CITY OF ALBUQUERQUE

**RE: Signal Pointe Subdivision
Pad Certification – All Pads
Engineer's Stamp Date 7-21-2016 (File: C20D0070)**

Based upon the information provided in your submittal received 9-20-2016 (electronic copy received 7-21-2016), the above referenced Grading and Drainage Plan is approved for Pad Certification of all Pads within the subdivision with the following condition:

VICINITY MAP

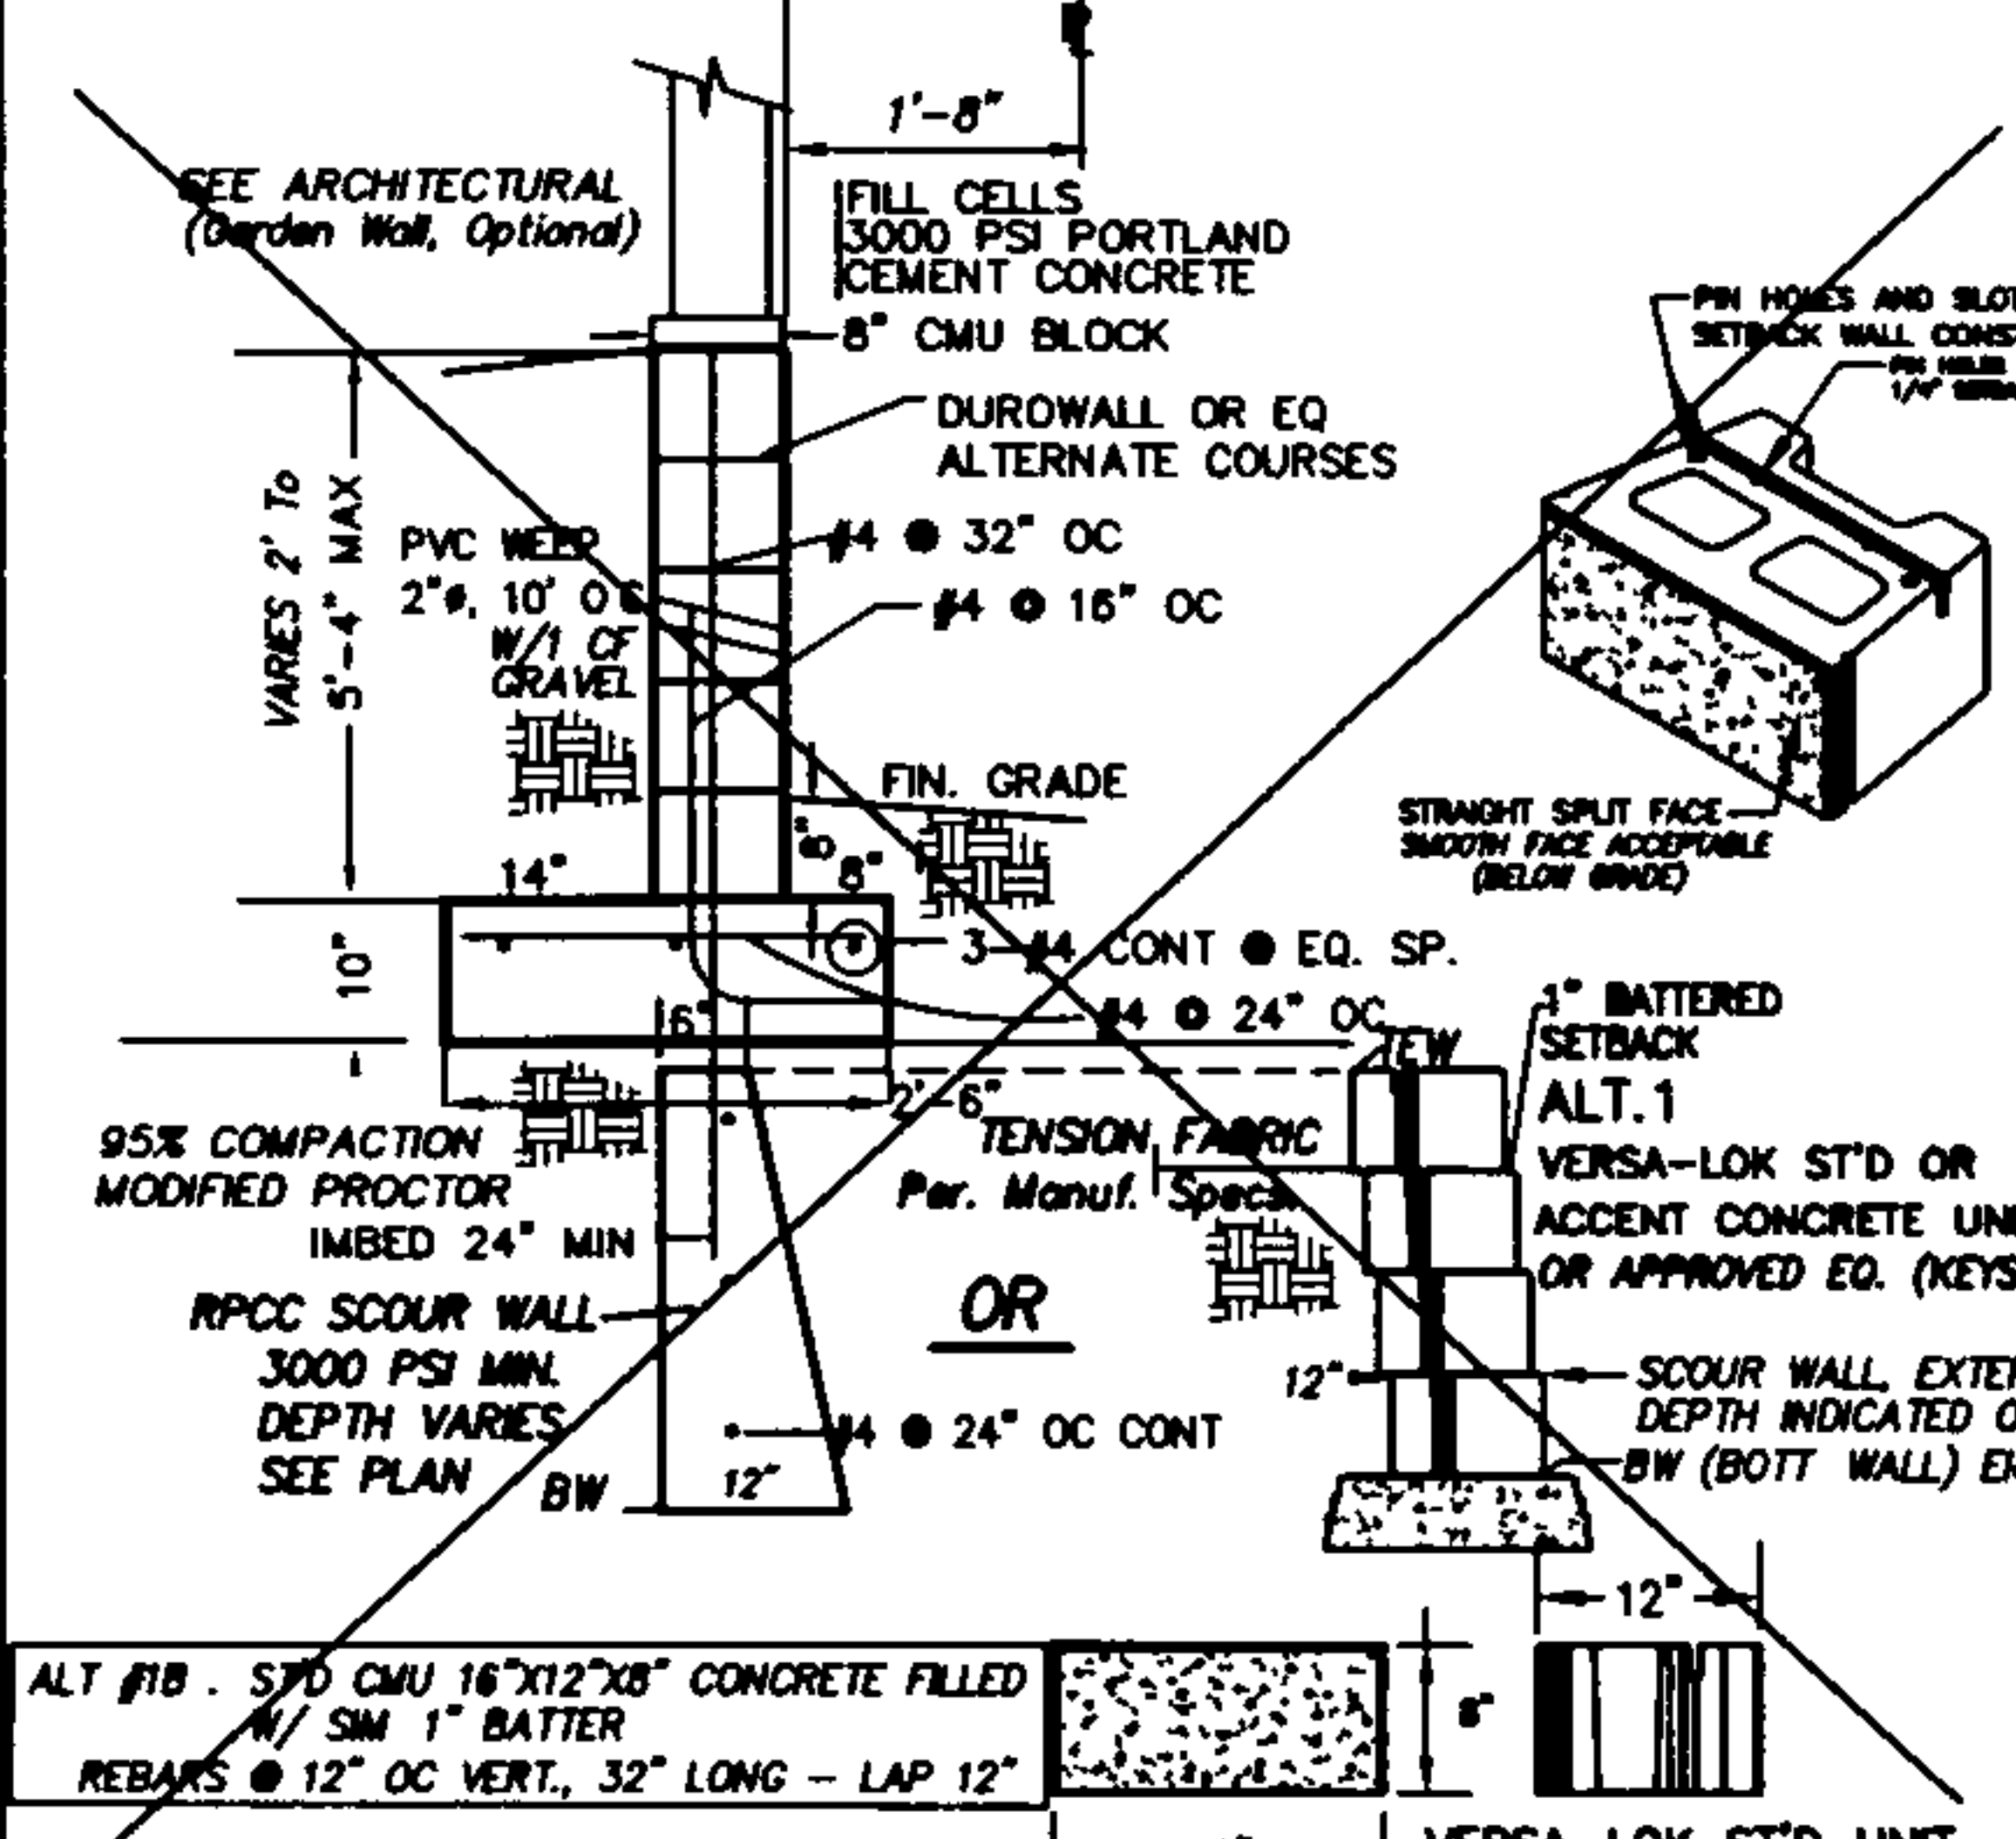
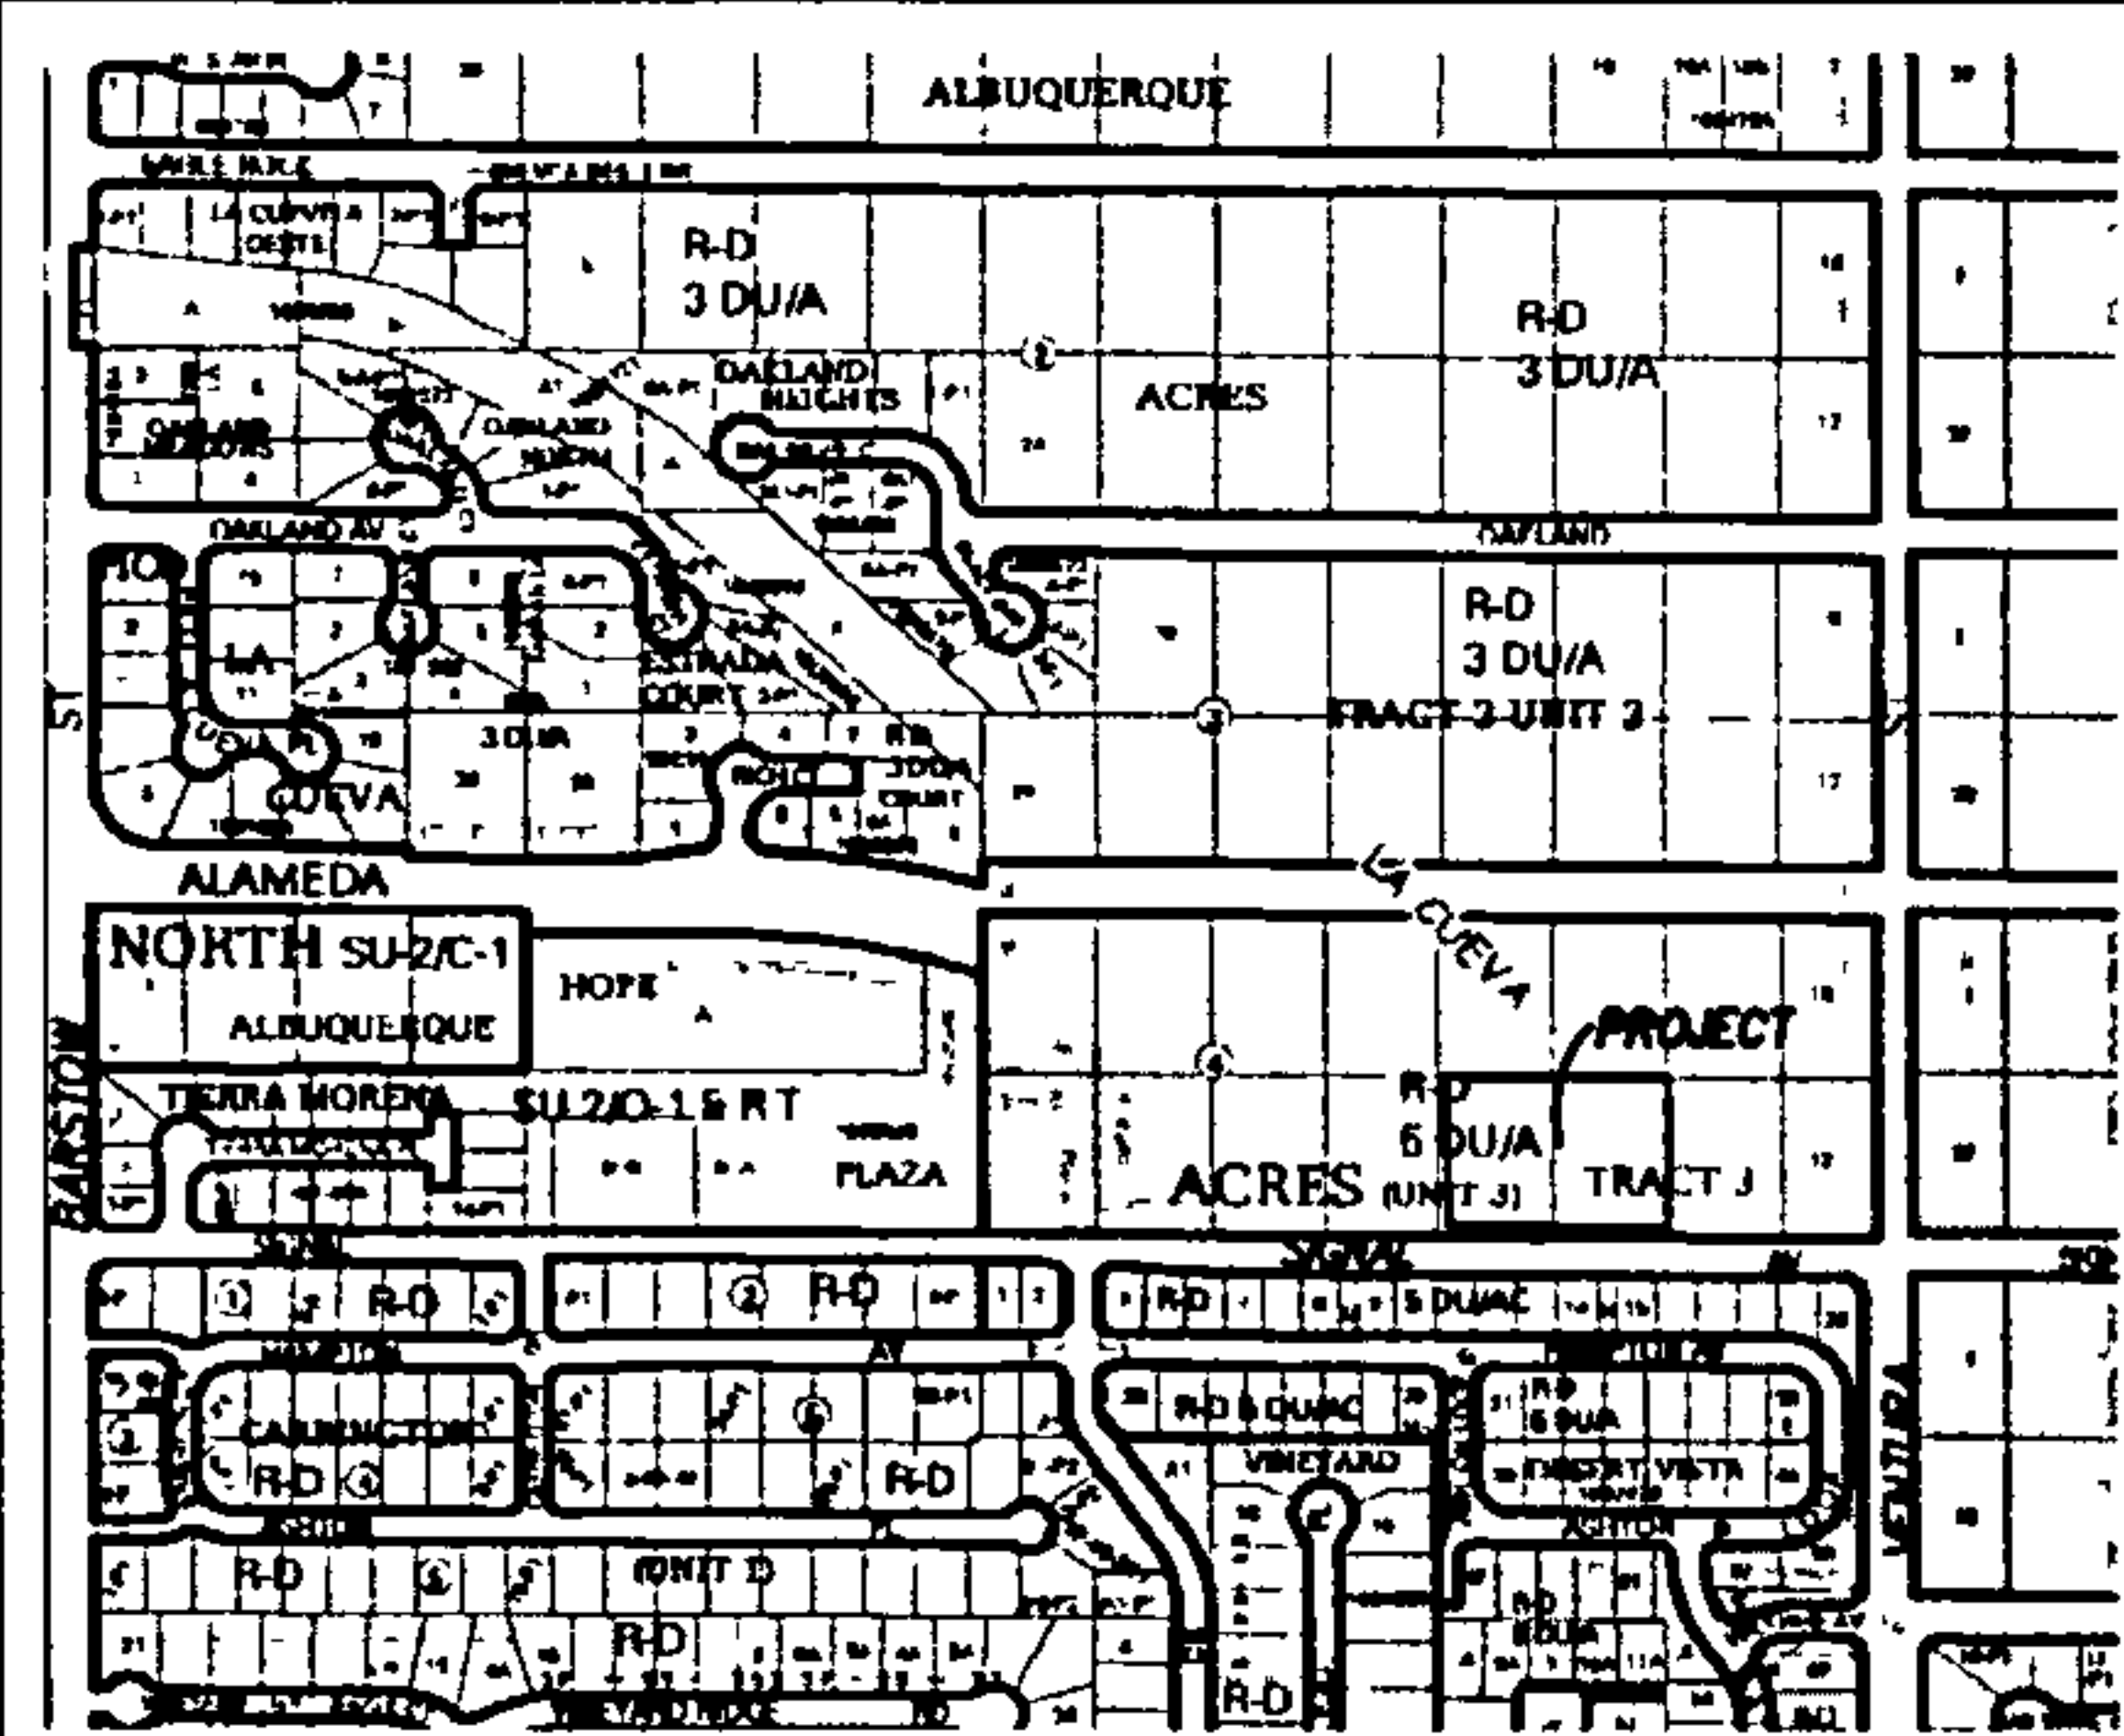
1. The turn blocks were not incorporated into the western wall, as an outlet for the water quality pond. This has the potential to adversely affect the home that is currently under construction on Lot 5 when the subdivision is built out. This will need to be addressed before any further action on this subdivision is approved (final plat, ROFG, future building permits).
